Geoffrey Sloan Associates

RE: Application for a non-material amendment to the approved applications at Charter Court, Linden Grove, New Malden, KT3 3BL.

I am writing in regards to the application for a non-material amendment to Royal Borough of Kingston upon Thames (RBK) planning approval 17/14632/FUL at Charter Court. The application proposes four changes to the approved scheme along with some general revisions to the elevations which are considered non-material in nature, these consist:

PROPOSED SIDE (SOUTH) ELEVATION

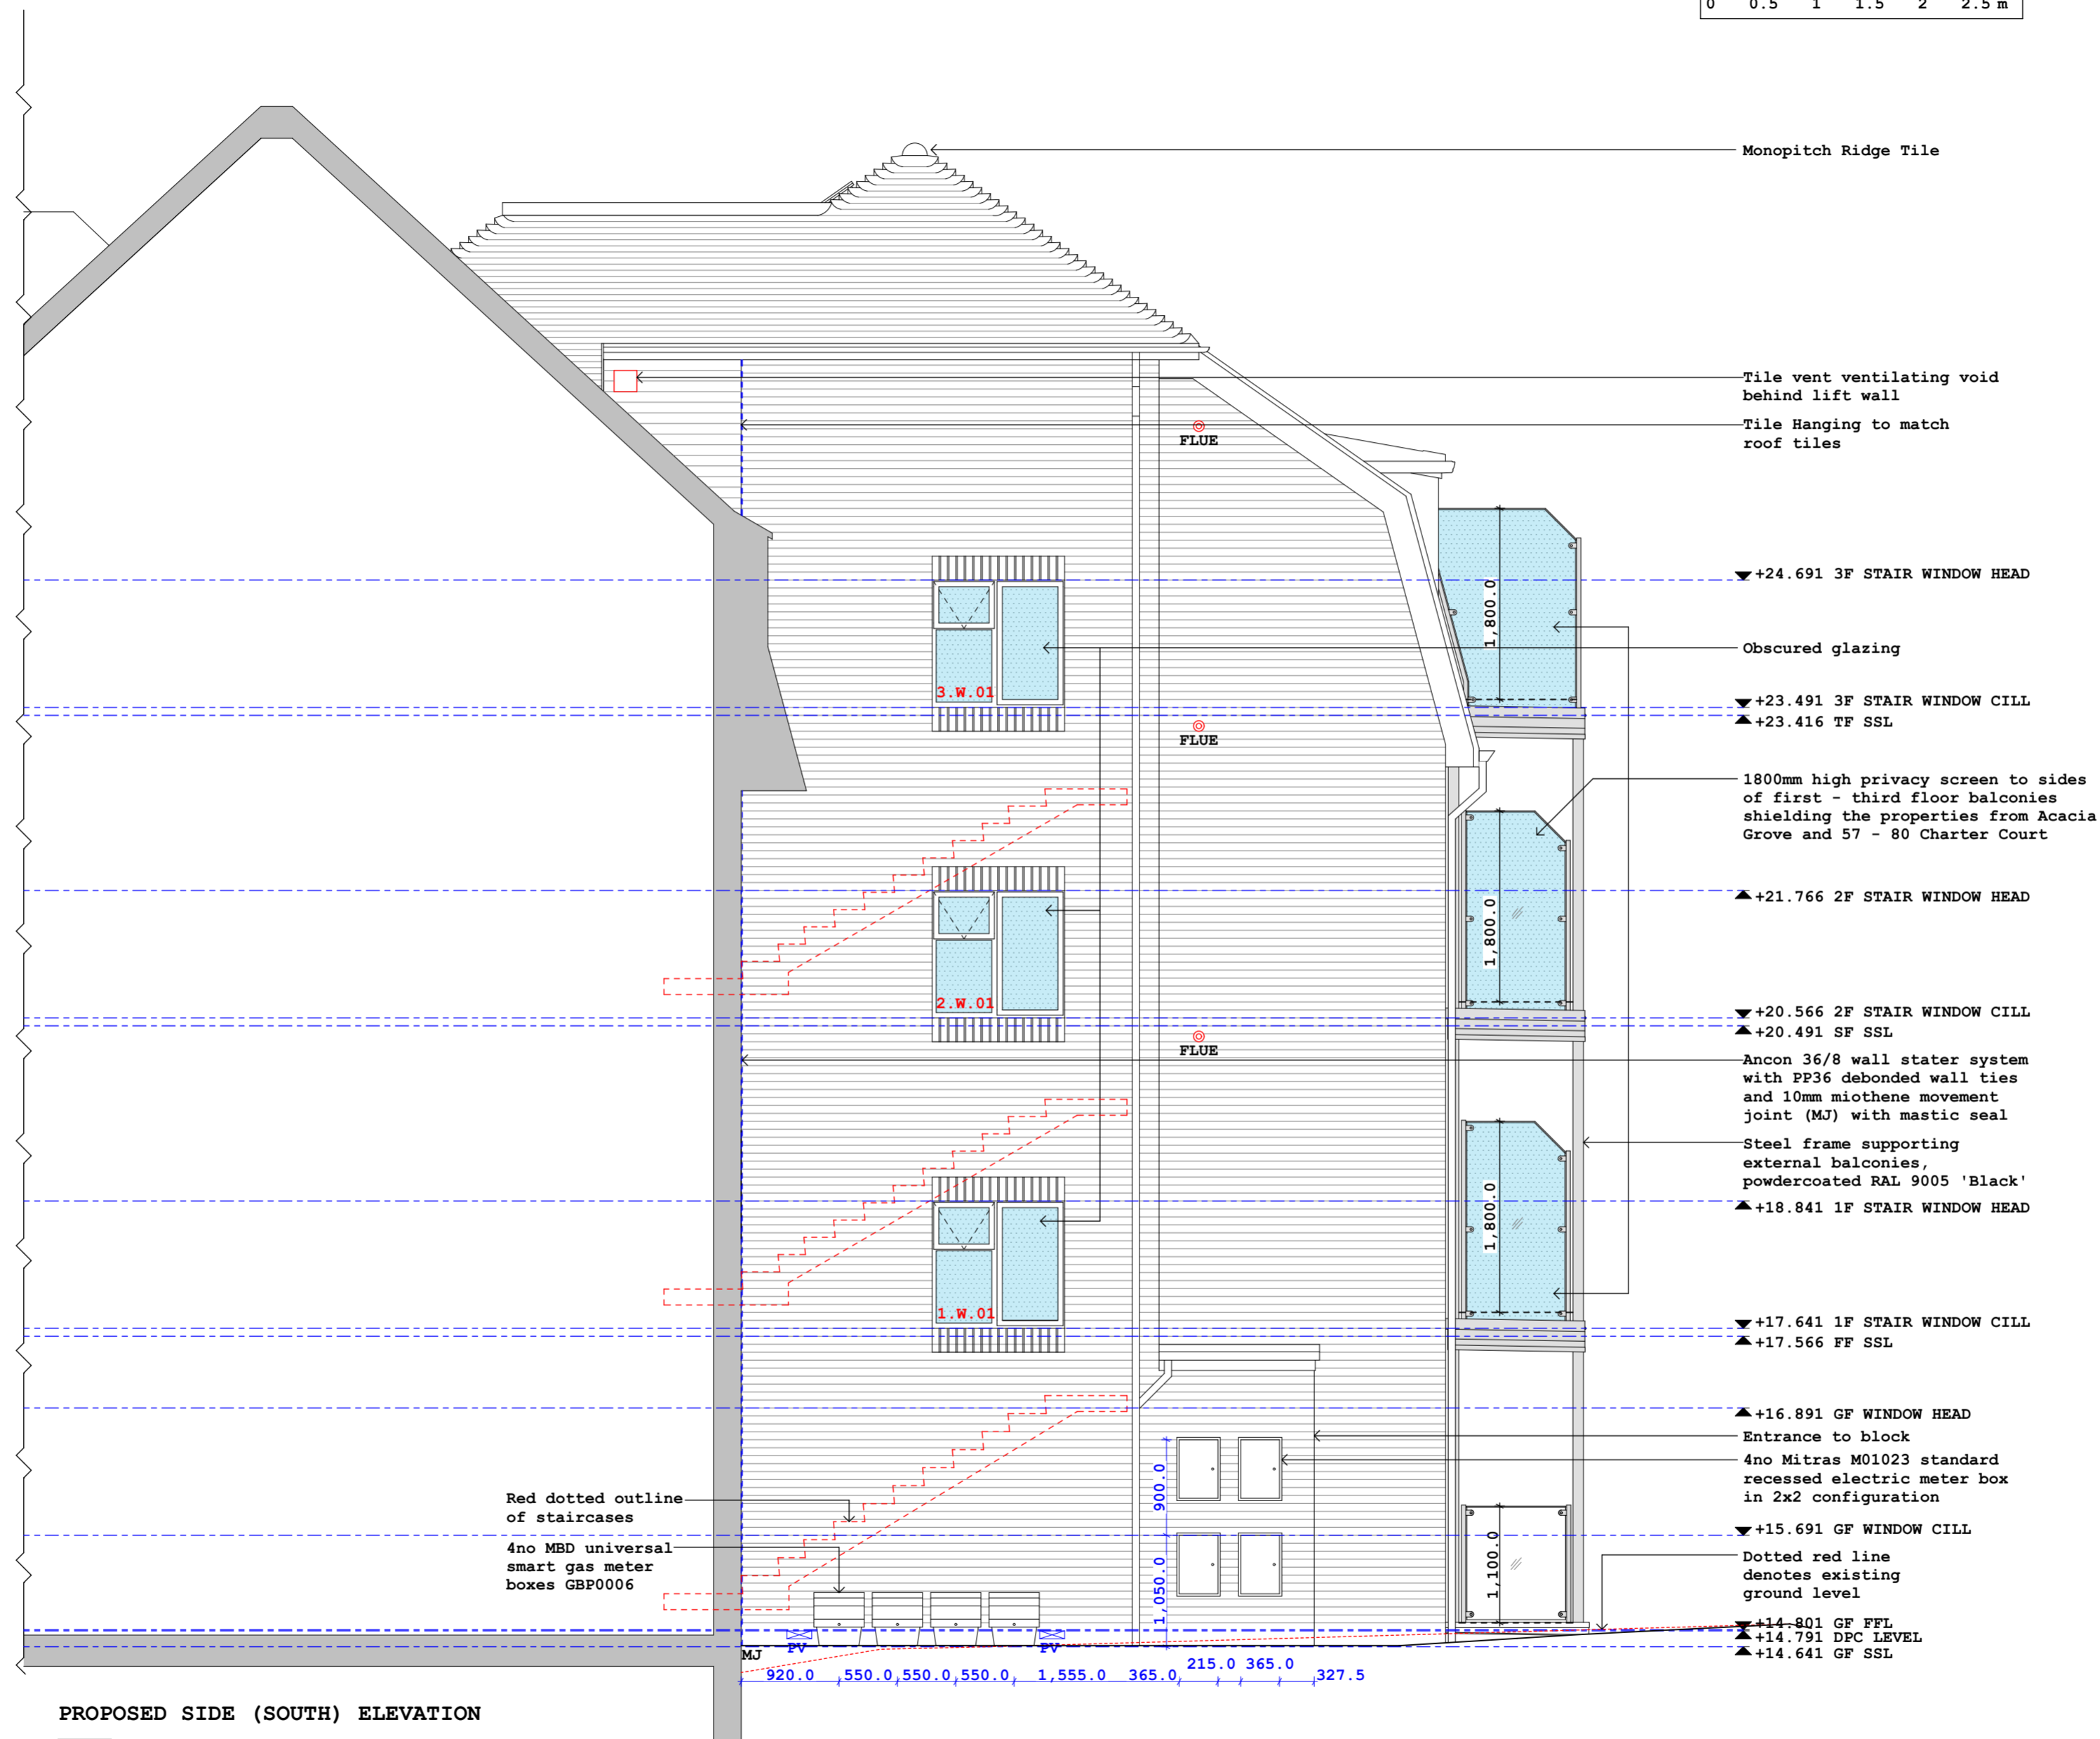
- A lead flashing has been added to the mansard change of pitch to provide suitable weathering.
- The provision of post boxes has been amended in the porch area.
- 4no electric meters have been built into the porch wall.
- Additional guttering has been provided to the Side (South) Elevation serving the porch roof.
- Subfloor vents, SVP stacks, boiler flues and extractor outlets have been added as necessary.

PROPOSED REAR (WEST) ELEVATION

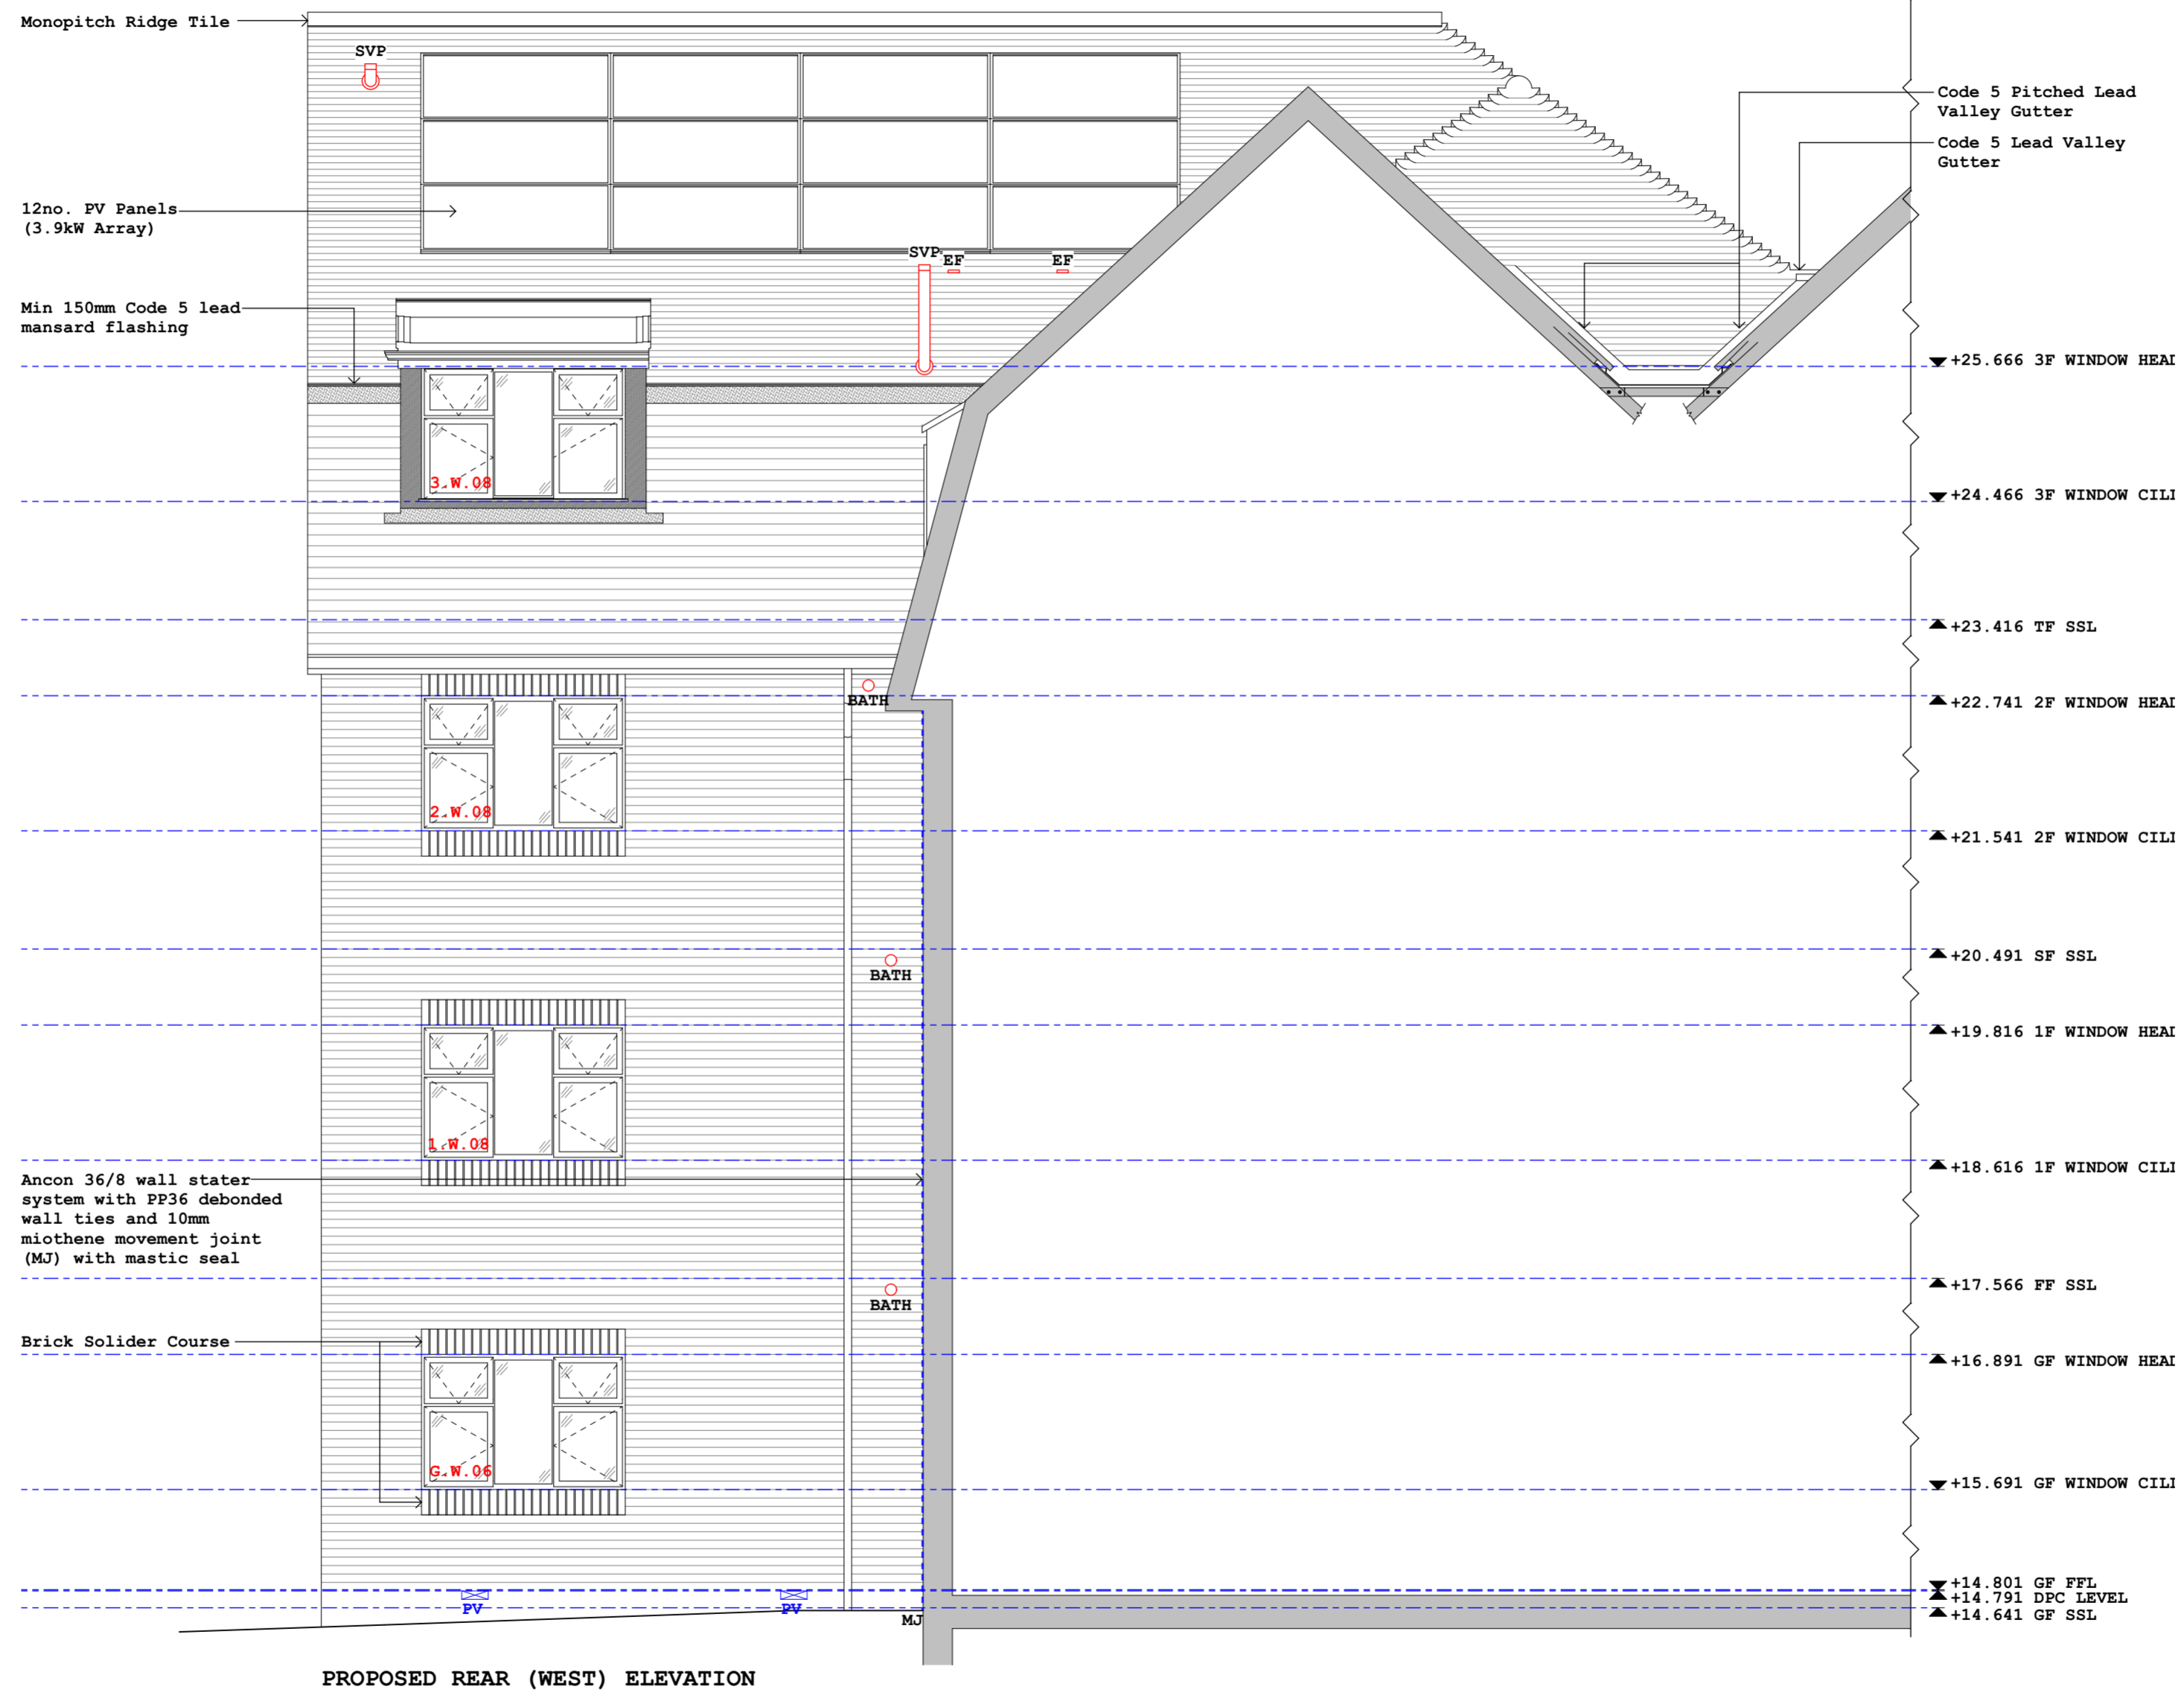
The proposed balconies have been revised to include slim aluminium fascia panels which provide an aesthetic improvement to the elevations. Black painted steel columns supporting the corners of the balconies have also been added. The proposed balustrading has been revised to suit these additional columns.

The proposed dormers have been reduced in depth in order to reduce the mansard flashing upstand to the window cill. This provides an aesthetic improvement to the elevations.
